Our Ref: AM/97017/Lw1

1st February 2023

RE: KINGS FOREST - ADAPTIVE MANAGEMENT REQUEST: PROPOSED AMENDED EXCLUSION FENCE DESIGN

KOALA FENCE ELEVATION
SCALE 1:10 - A1 (1:20 - A3)

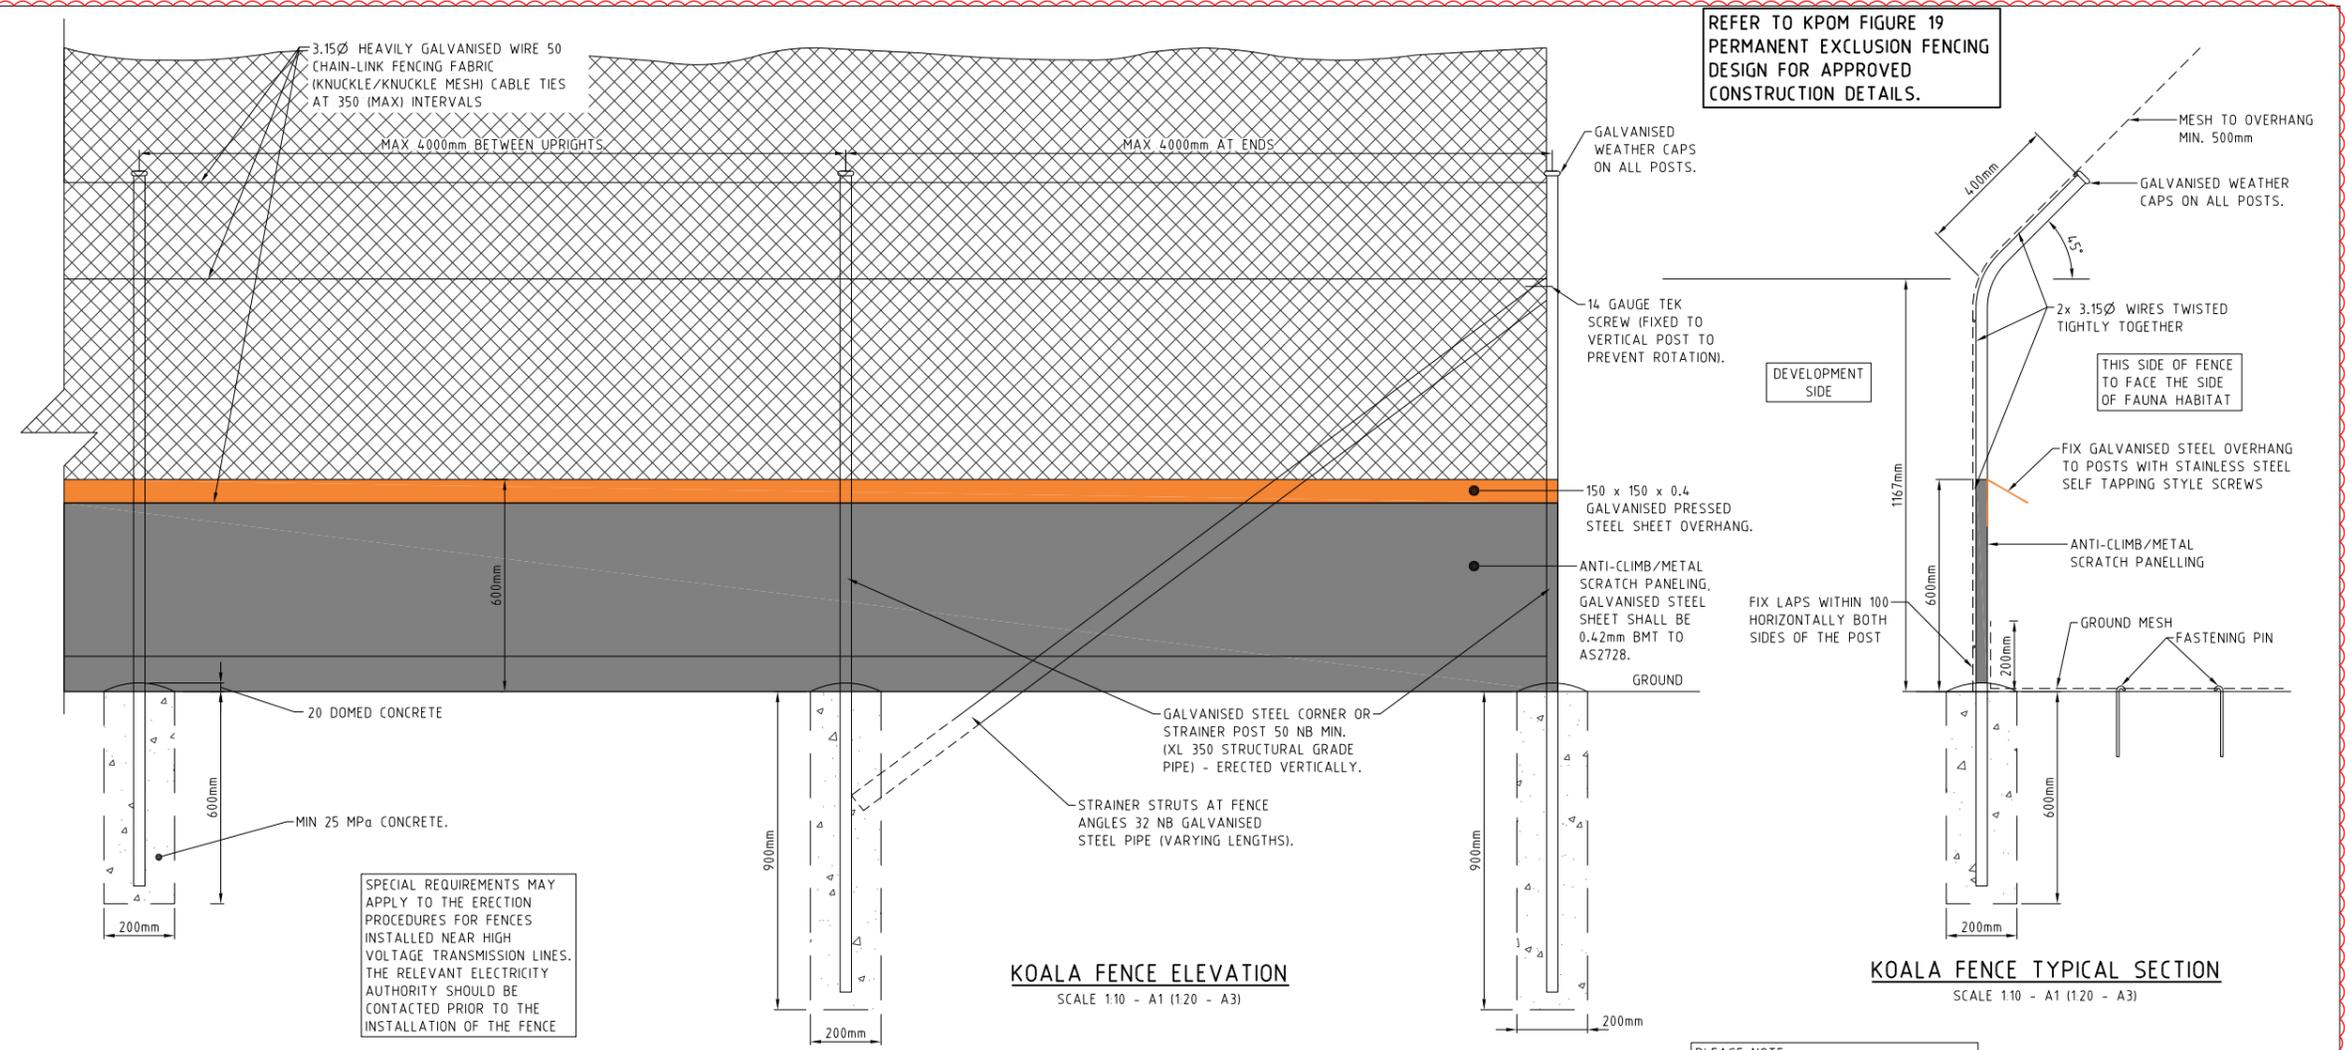
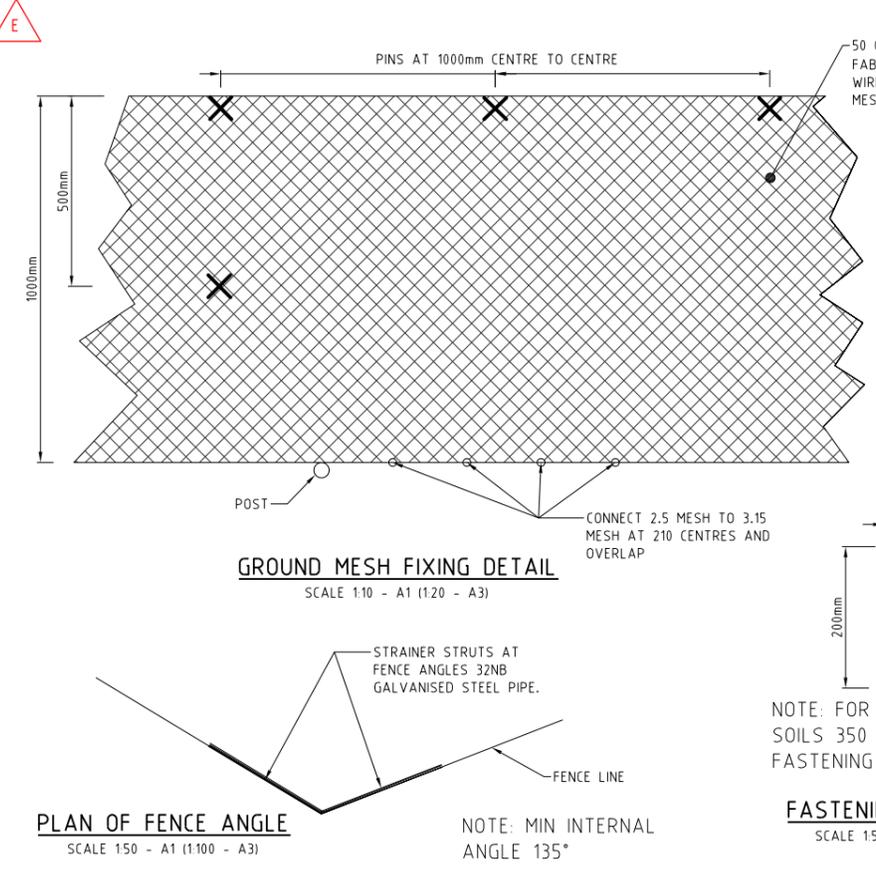
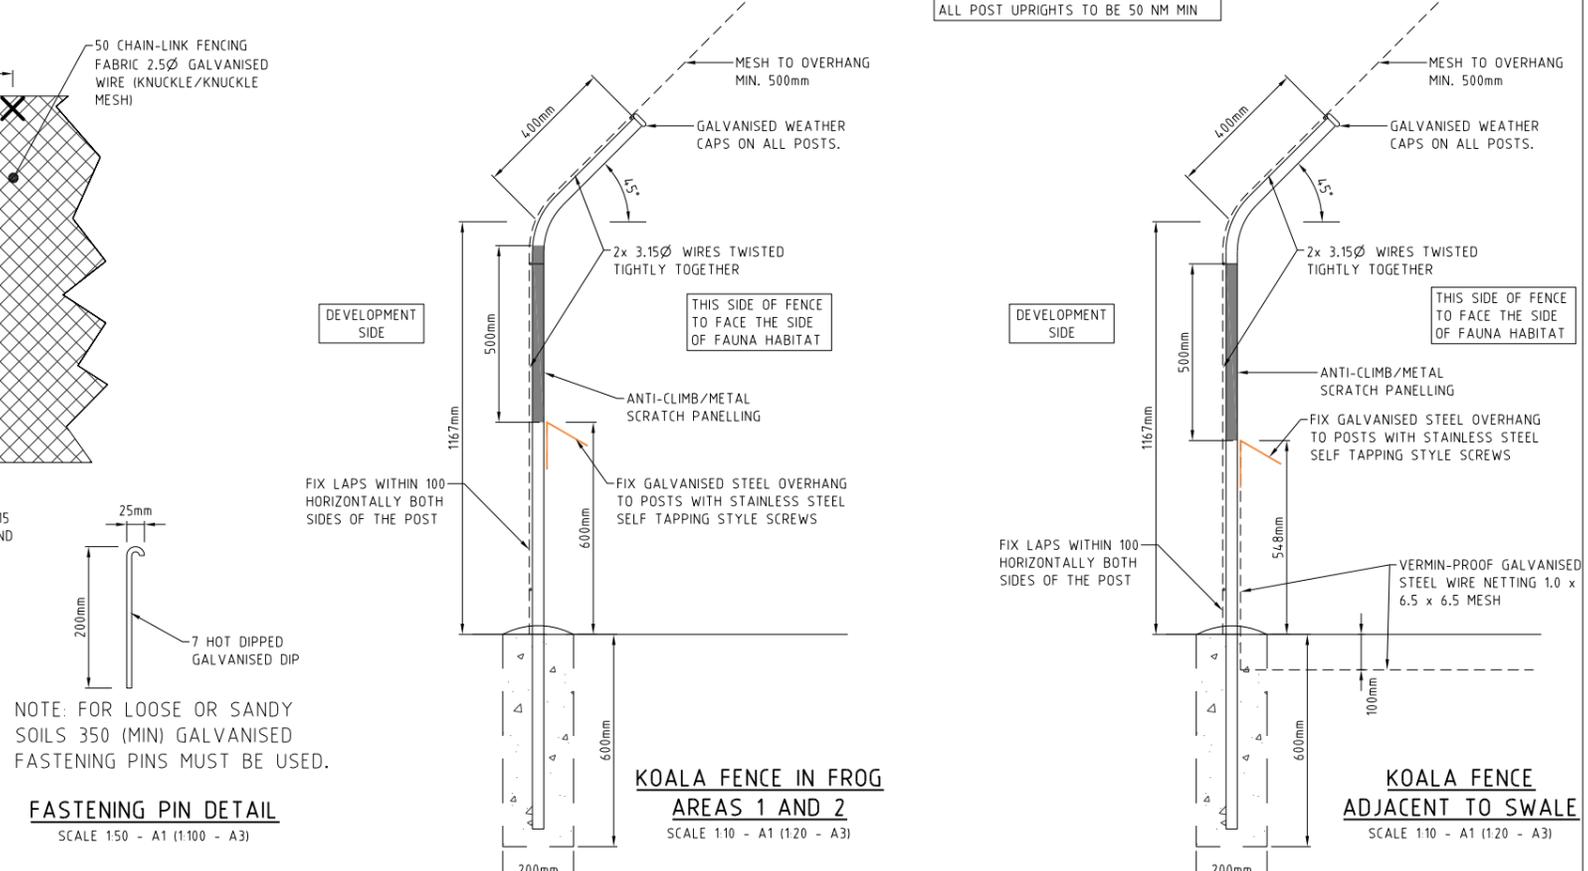
The current approved design for permanent exclusion fencing is detailed in various management plans and allows for the following design features:

- 1.5 m high floppy top fencing with an attached 60 cm wide metal sheeting along the bottom of the fence; and
- A galvanised steel overhang (lip) to discourage frogs from climbing over the fence.

The proposed amended exclusion fence design will involve the following three (3) main changes:

- Removal of the floppy top to be replaced with a straight 1.5 m vertical fence;
- Replacement of the 60 cm wide metal sheeting with 60 cm wide anti-climb UV resistant hard plastic panelling to increase their longevity; and
- Removal of the galvanised steel lip (overhang) which was to discourage frogs from scaling the fence.

The proposed amended exclusion fence will utilise two (2) design variations characterised by the above features over different sections of the Kings Forest estate. The use of the design variations will be determined by ground conditions:

- Non-wetland areas - The exclusion fencing will have the anti-climb panels sitting approximately 10 cm above the ground. This fence type is only designed to stop Koala movements. Tweed Shire Council have requested that the panels be raised off the ground so as to increase their longevity.
- Wetland/wallum sedge frog habitat areas - The exclusion fencing will have the panels sitting into the ground by 5 cm so as to stop Wallum sedge frog and Koala movements. No vehicular or pedestrian access gates will be included in permanent fauna exclusion fencing adjoining Wallum sedge frog habitat. Tweed Shire Council are accepting of the panels sitting in the ground due to the need to stop frog movements.
